M3 Junction 9 Improvement Scheme

Hampshire County Council's Response to the Examining Authority's Questions – 25 May 2025

DRAWING TITLE
**GENERAL ARRANGEMENT PLANS
 APPP REGULATION 5(2)(c)
 SHEET 5 OF 10
 DOCUMENT REFERENCE: 2.5**

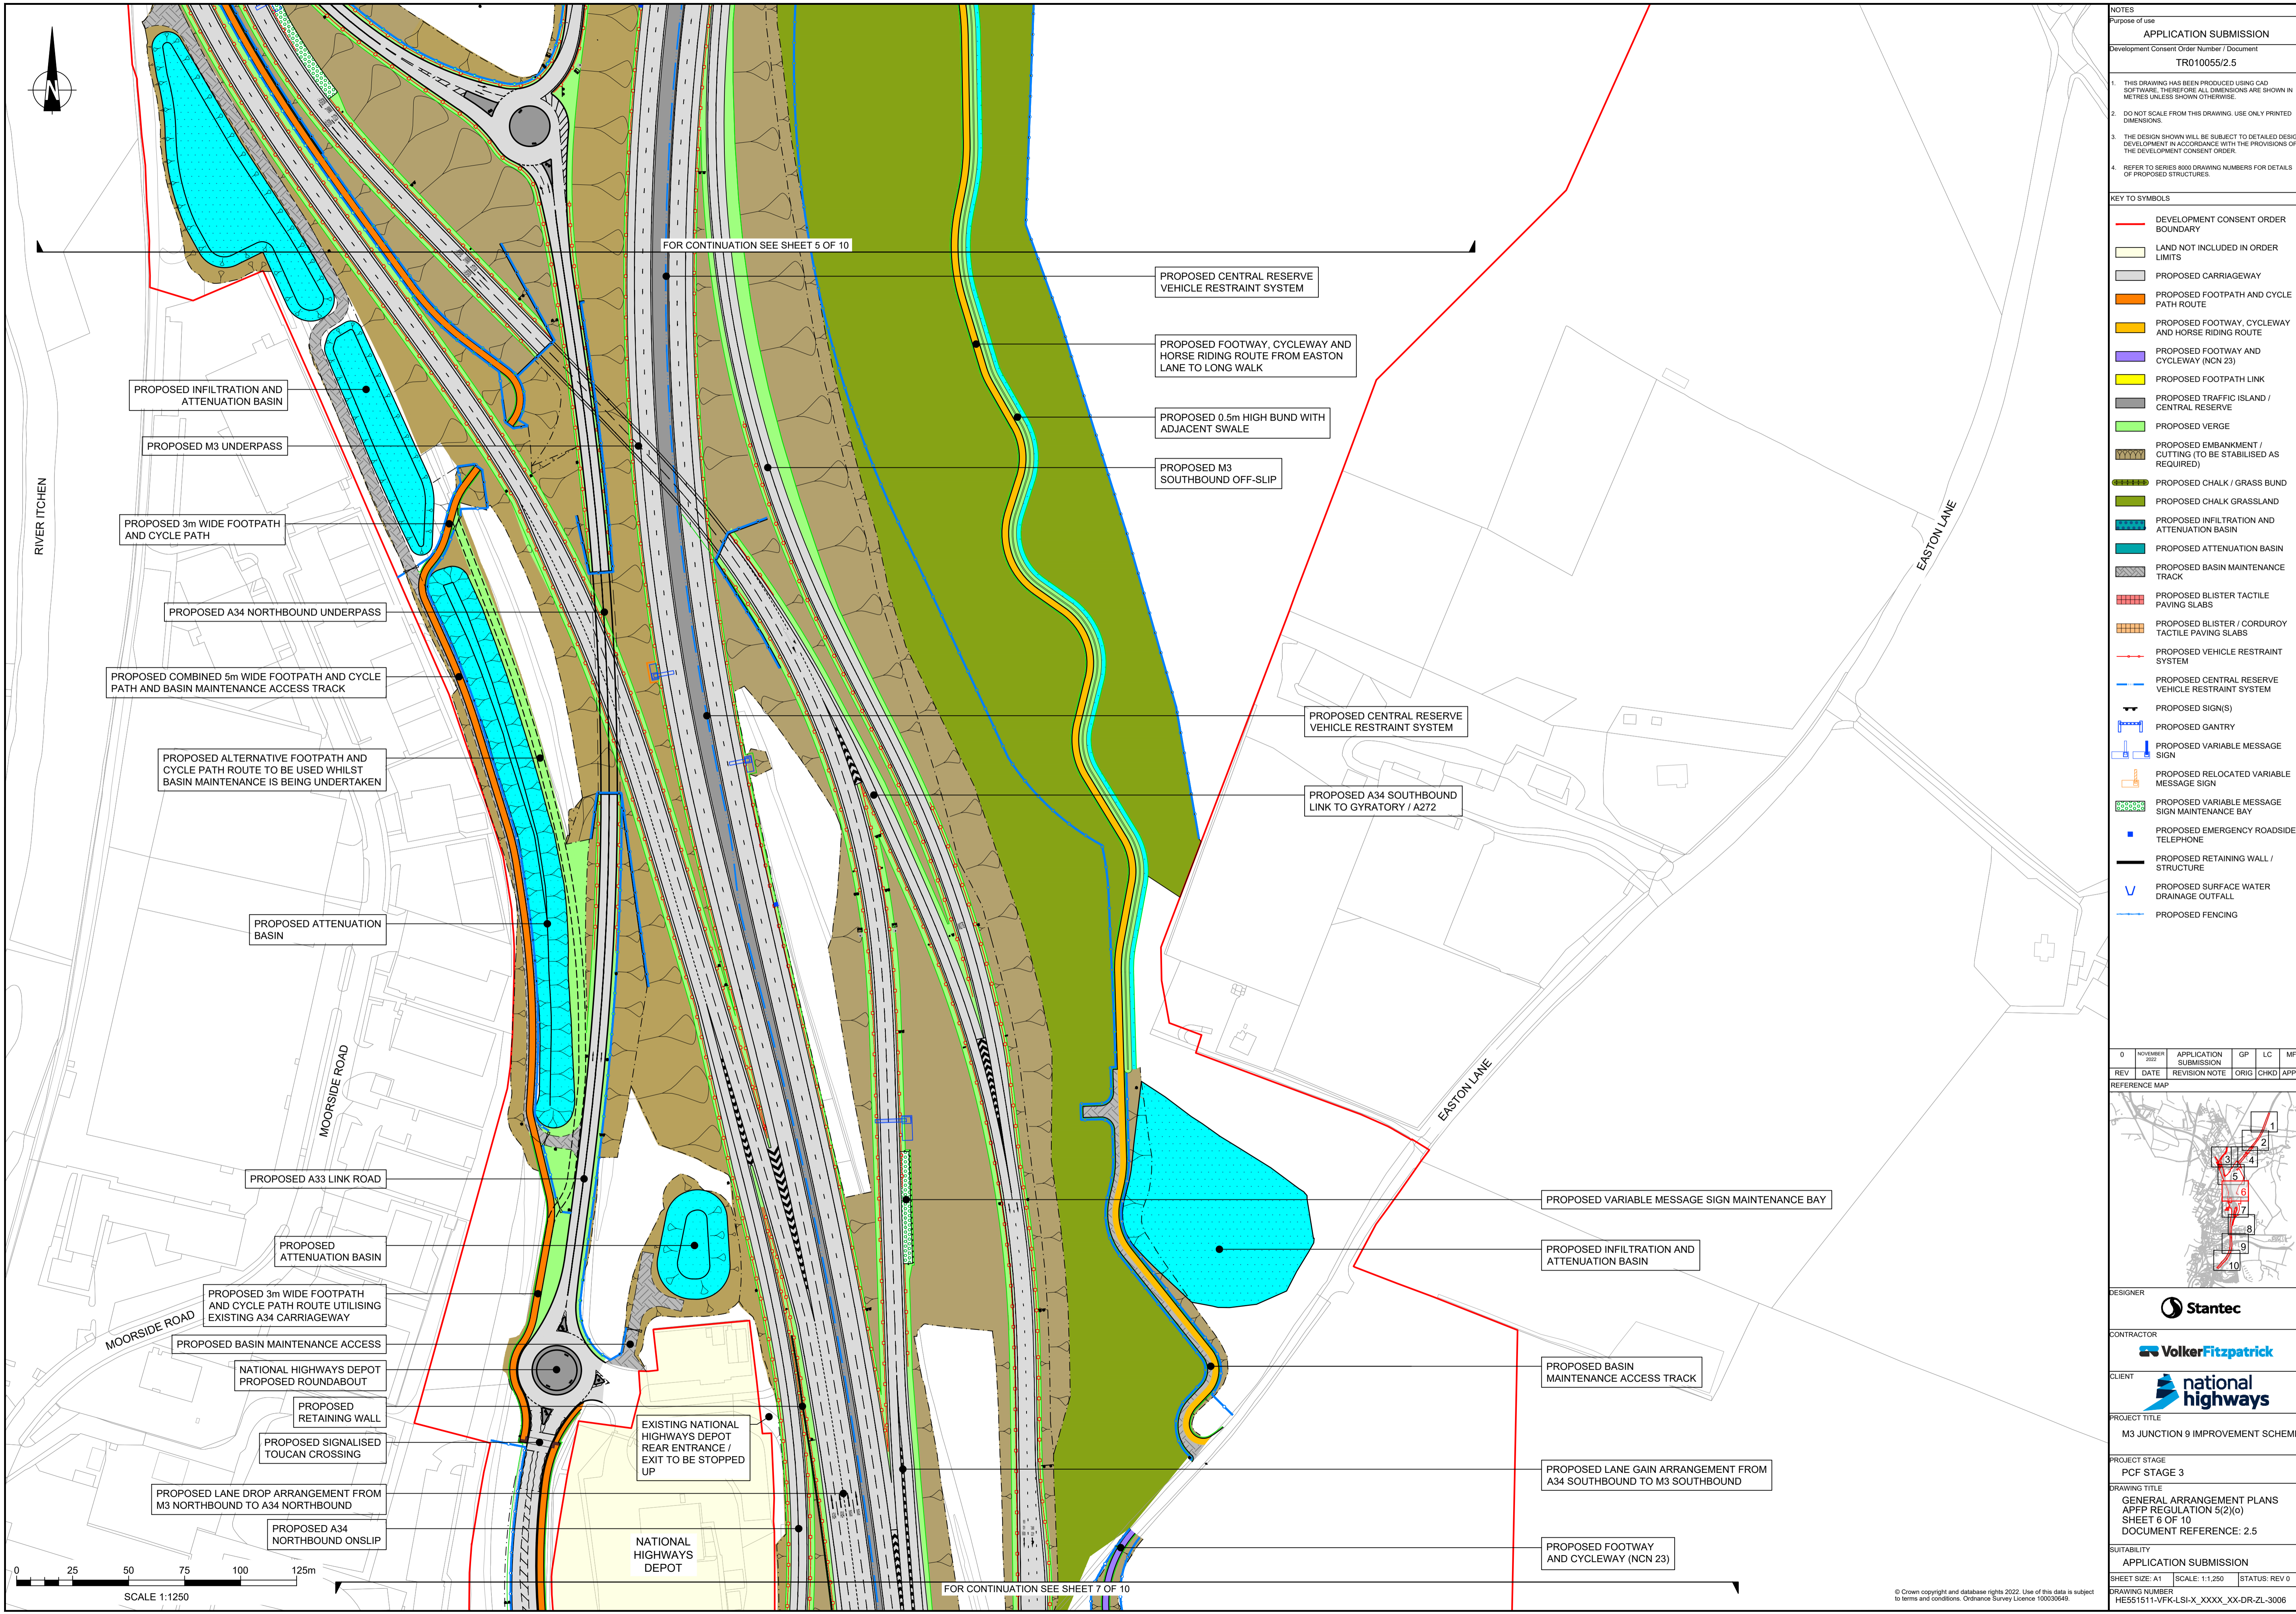
The cycle track is bounded by fencing along most of its route. Where it is contiguous with the trunk road, as show in General Arrangement Plans sheets 5 and 6, the highway authority would not expect to maintain the fence between the cycle track and the trunk road.

The County Council is still in discussion with National Highways regards whether it would accept responsibility for the bridge structure that will carry the right of way as shown on General Arrangement Plans sheet 5.

The County Council does not accept the transfer of responsibility for any subway structure as shown on General Arrangement Plans sheet 5 that carries or accommodates the route of the highway.

DRAWING TITLE
**GENERAL ARRANGEMENT PLANS
 APPP REGULATION 5(2)(c)
 SHEET 6 OF 10
 DOCUMENT REFERENCE: 2.5**

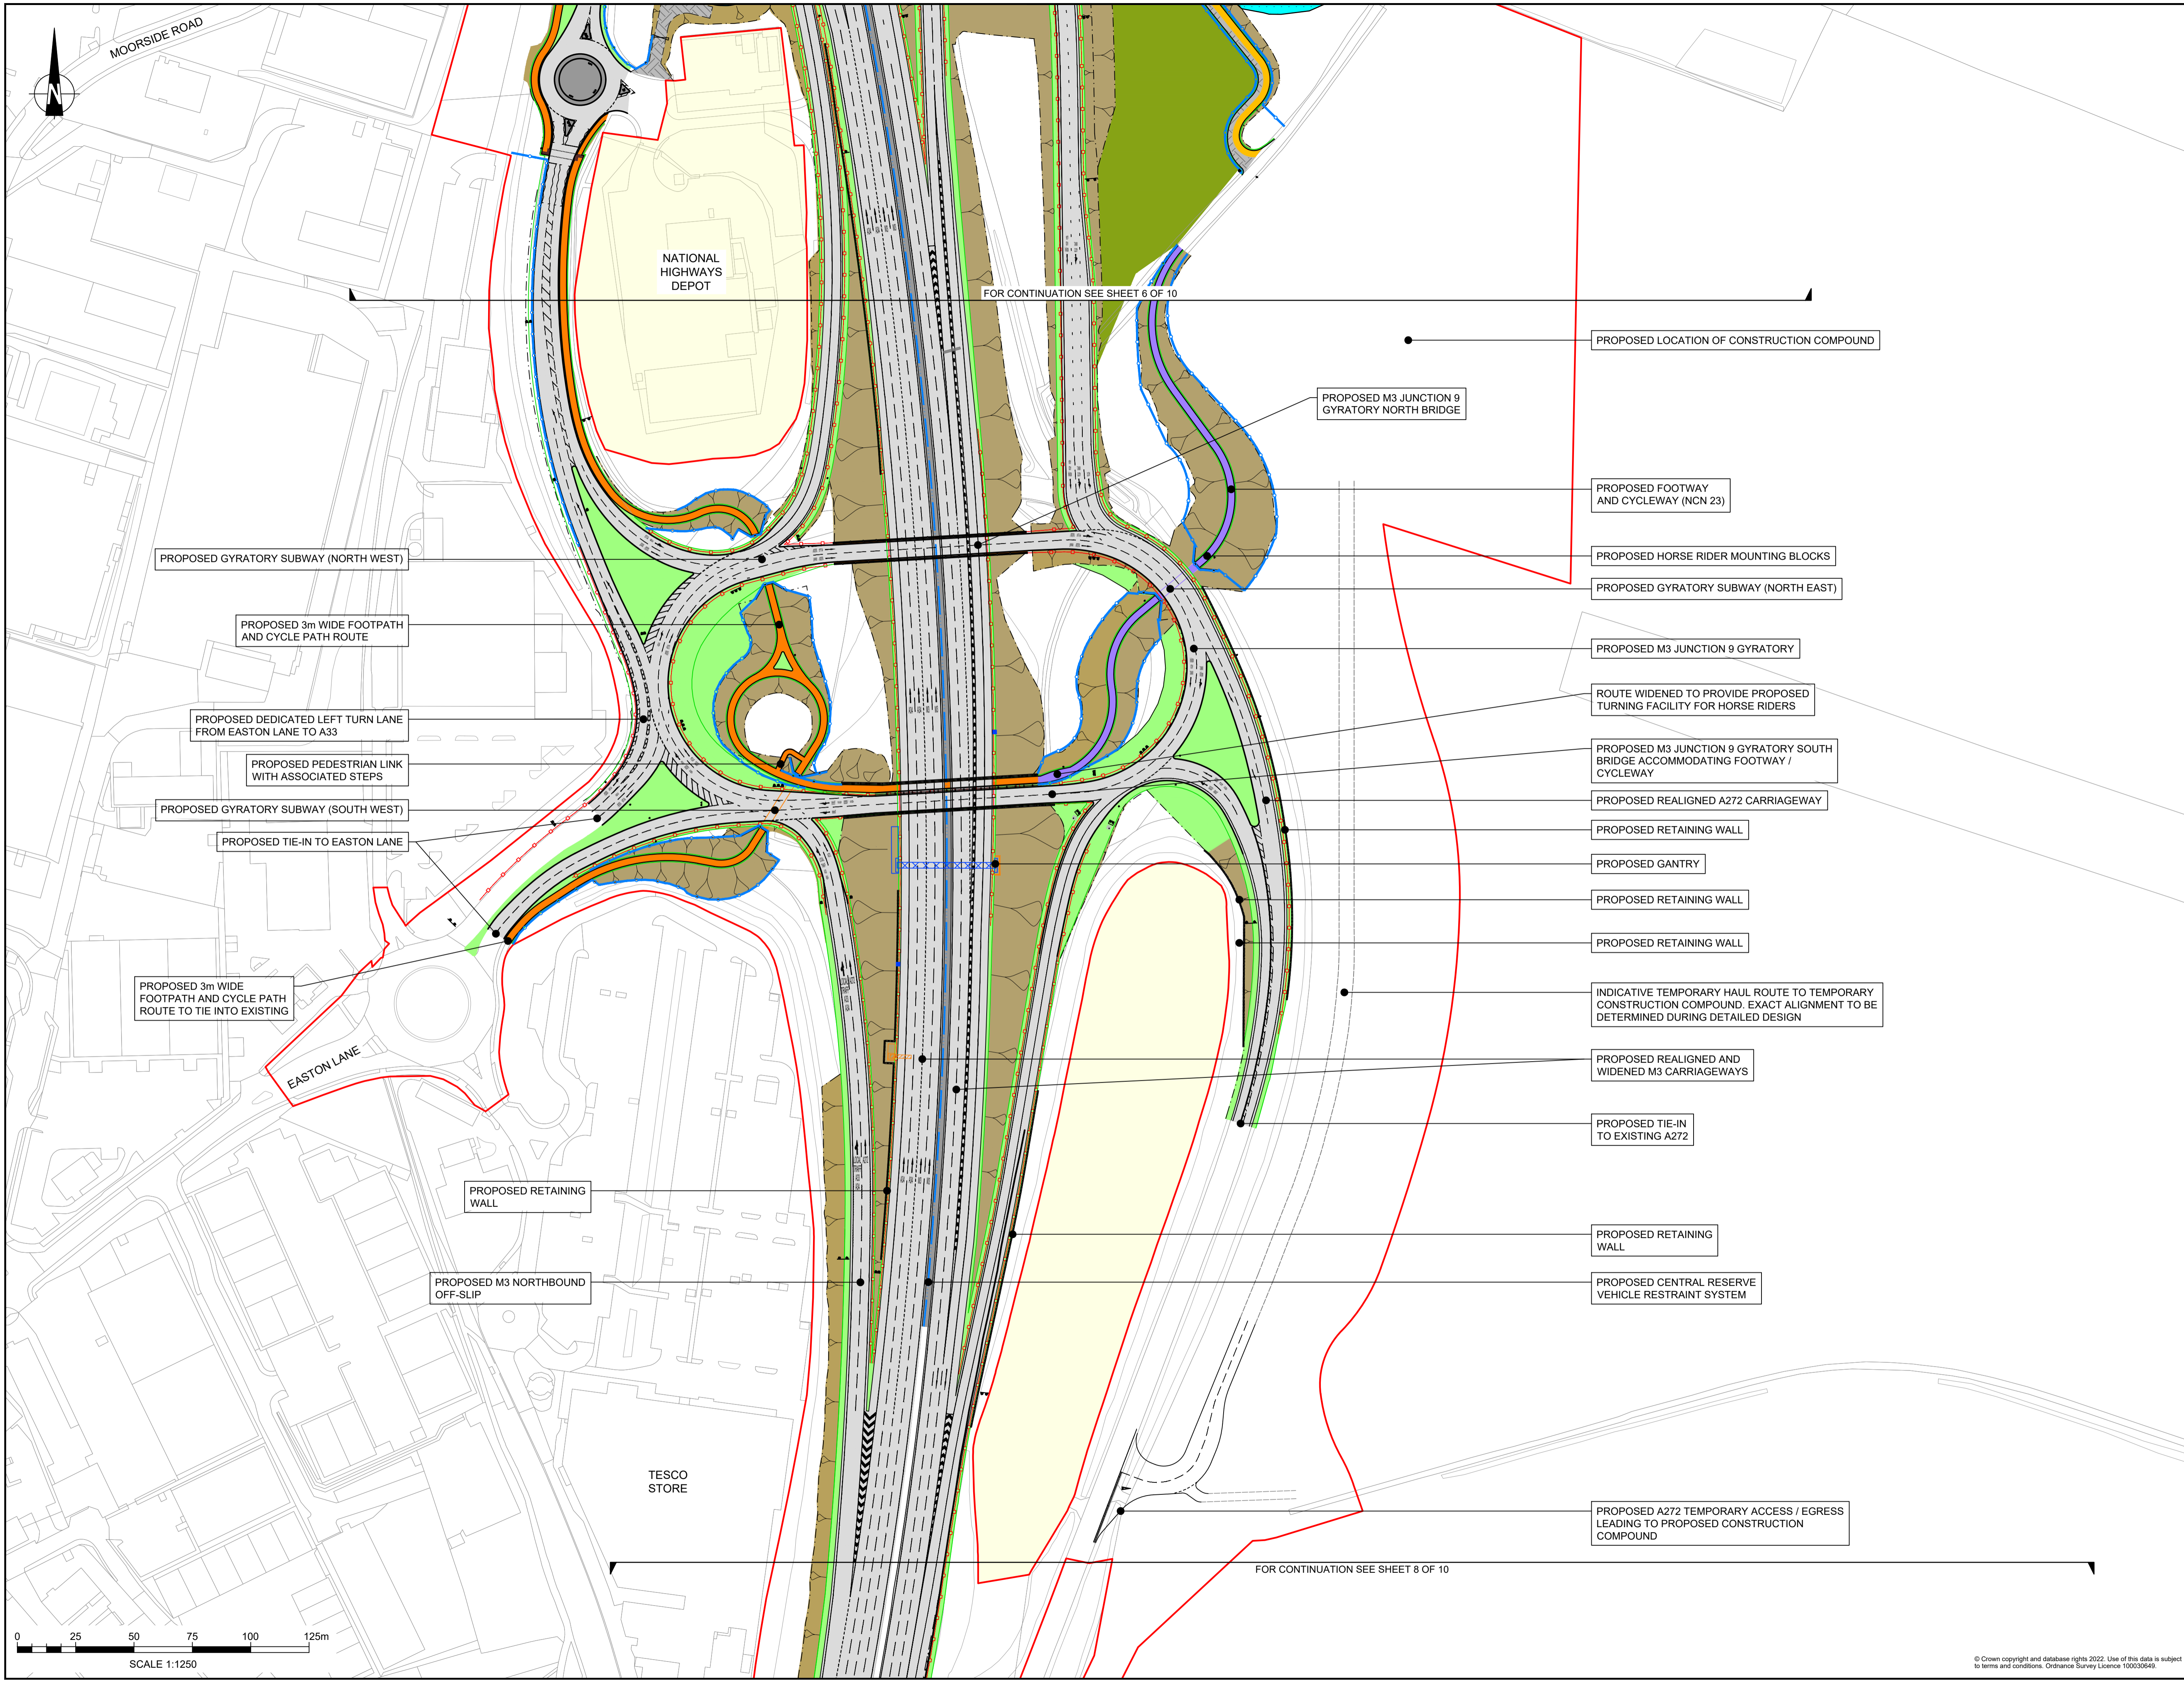
As shown on General Arrangement Plan sheet 6, the proposed Toucan crossing on the A33 Link Road on the southern arm of the National Highways depot will not be transferred to the County Council's ownership as this crosses part of the trunk road network. The cycle track either side will be maintained by the County Council.
